H13-0595-11
04 AUG 2011

Application for a non-material amendment following a grant of planning permission.

EXTENSIONS & ALTERATIONS.

H13-1010-10. / H13-1011-10

Drawing
FLOOR PLANS & ELEVATIONS.
SITE & LOCATION PLANS.

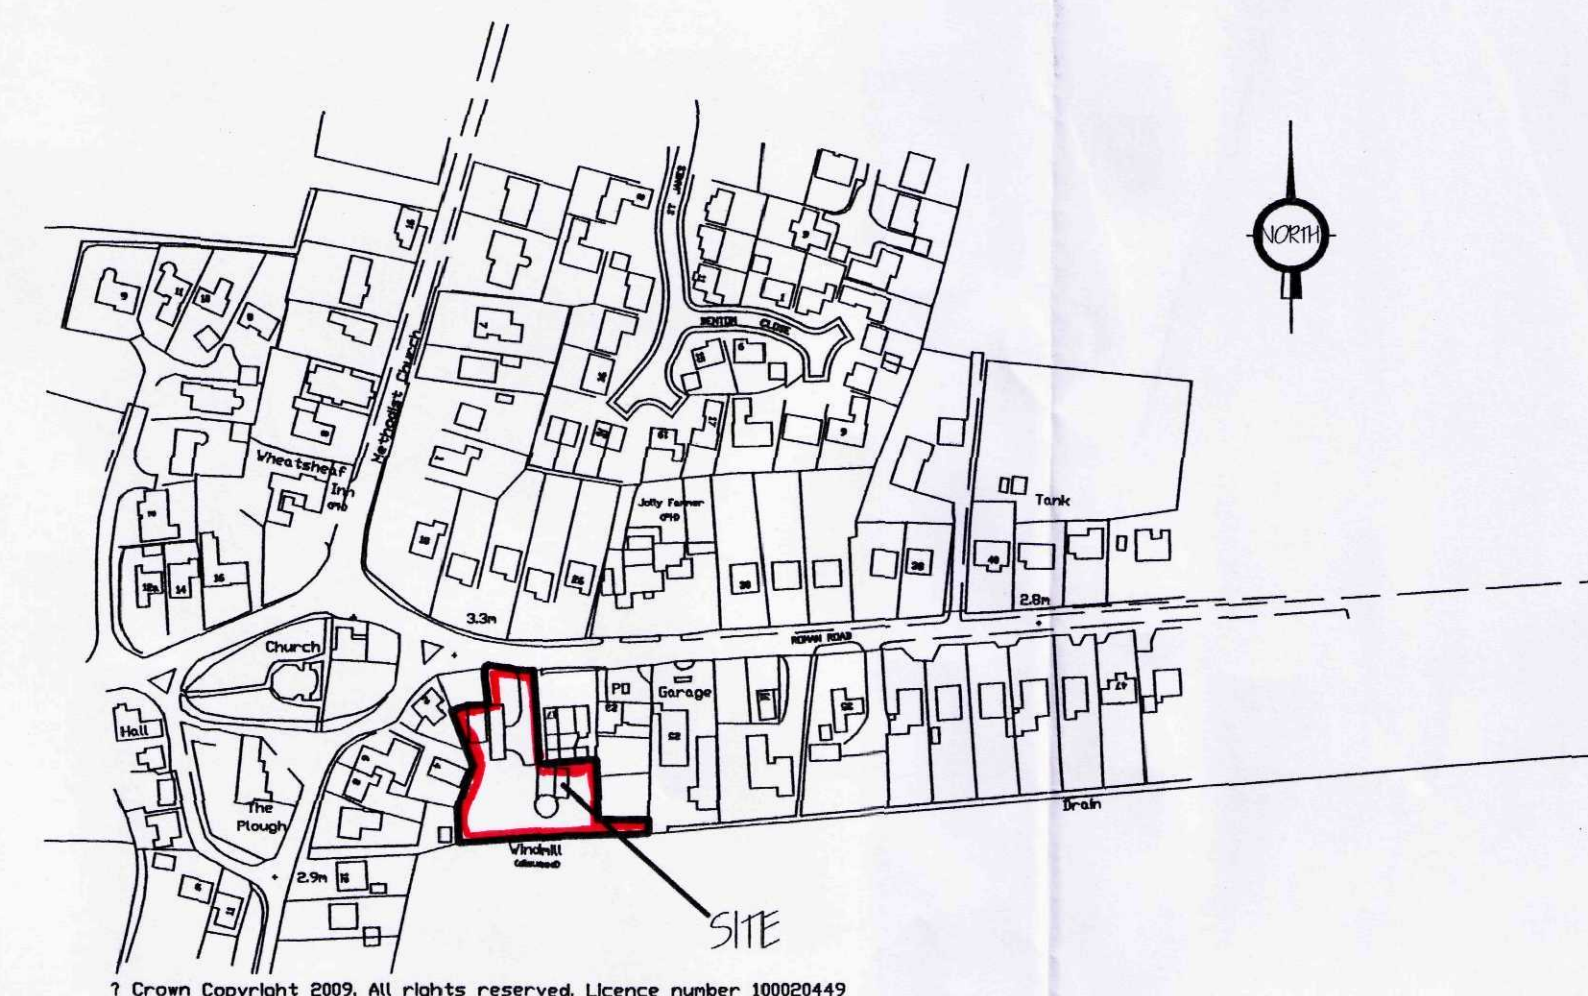
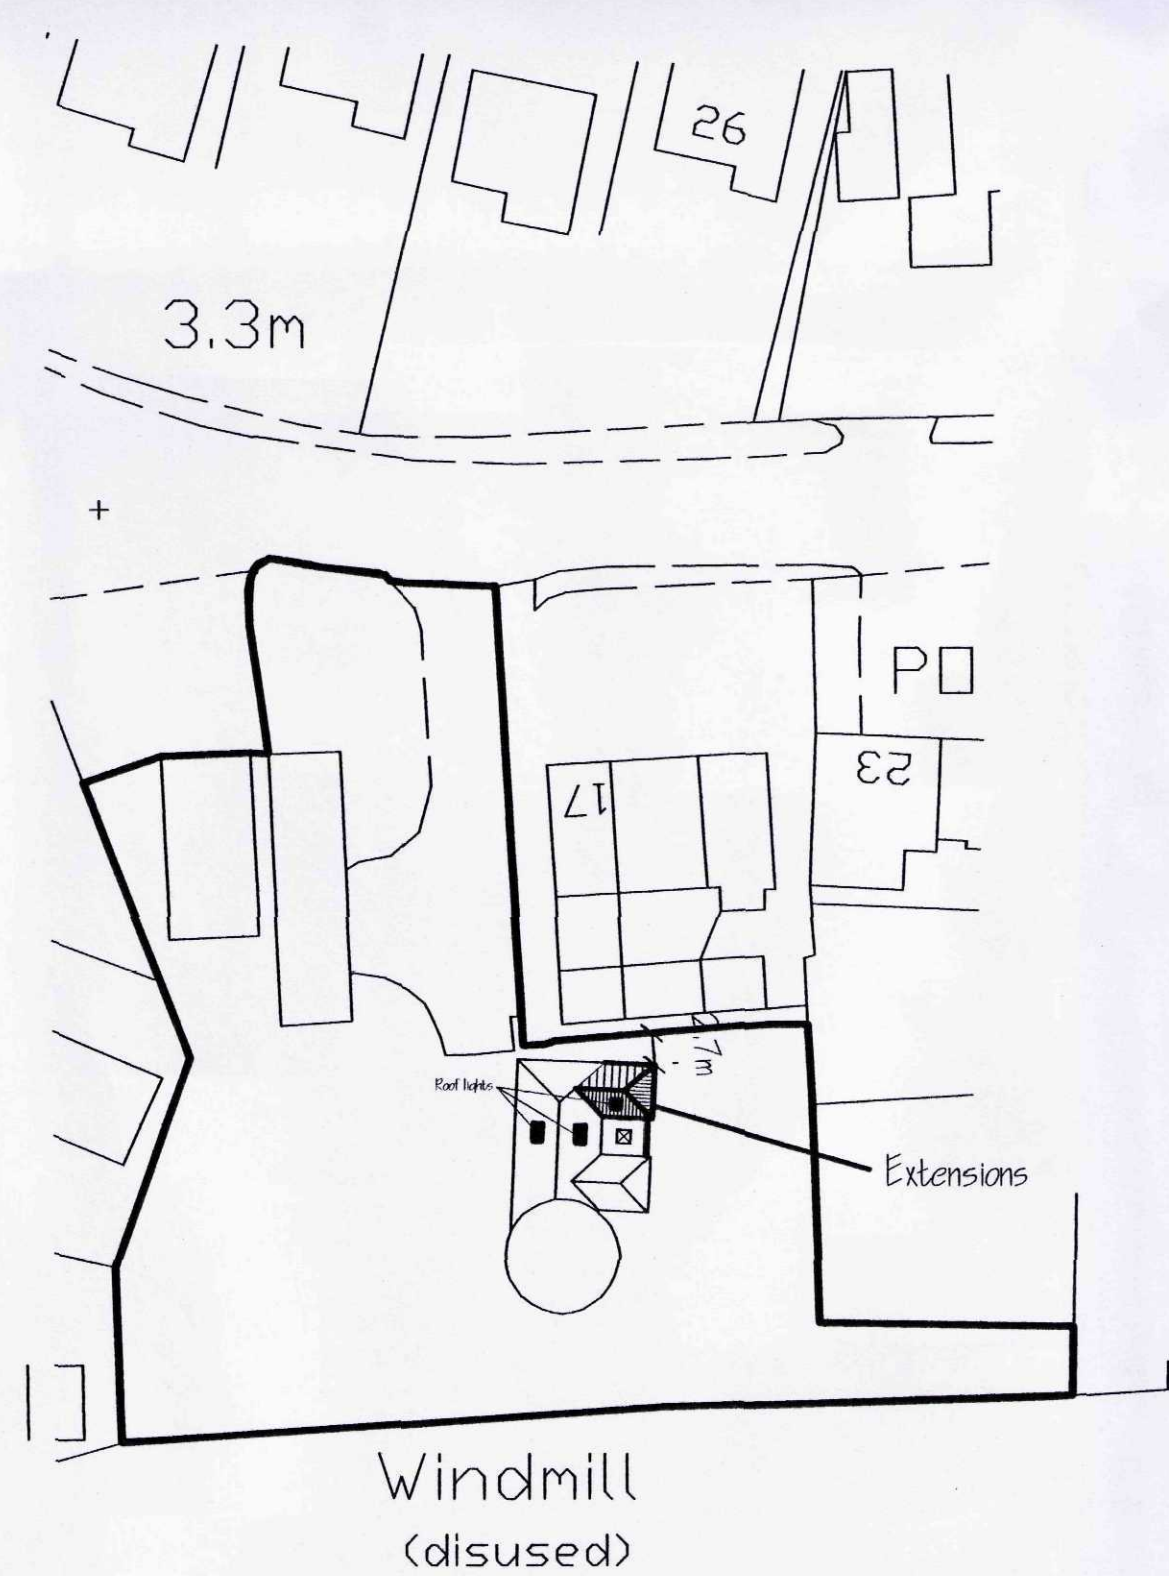
DOME TO CONSERVATORY ROOF

2164-10-01A.

2164-10-01C, 2164-10-02.

TO INCREASE AMOUNT OF NATURAL LIGHT IN CONSERVATORY.
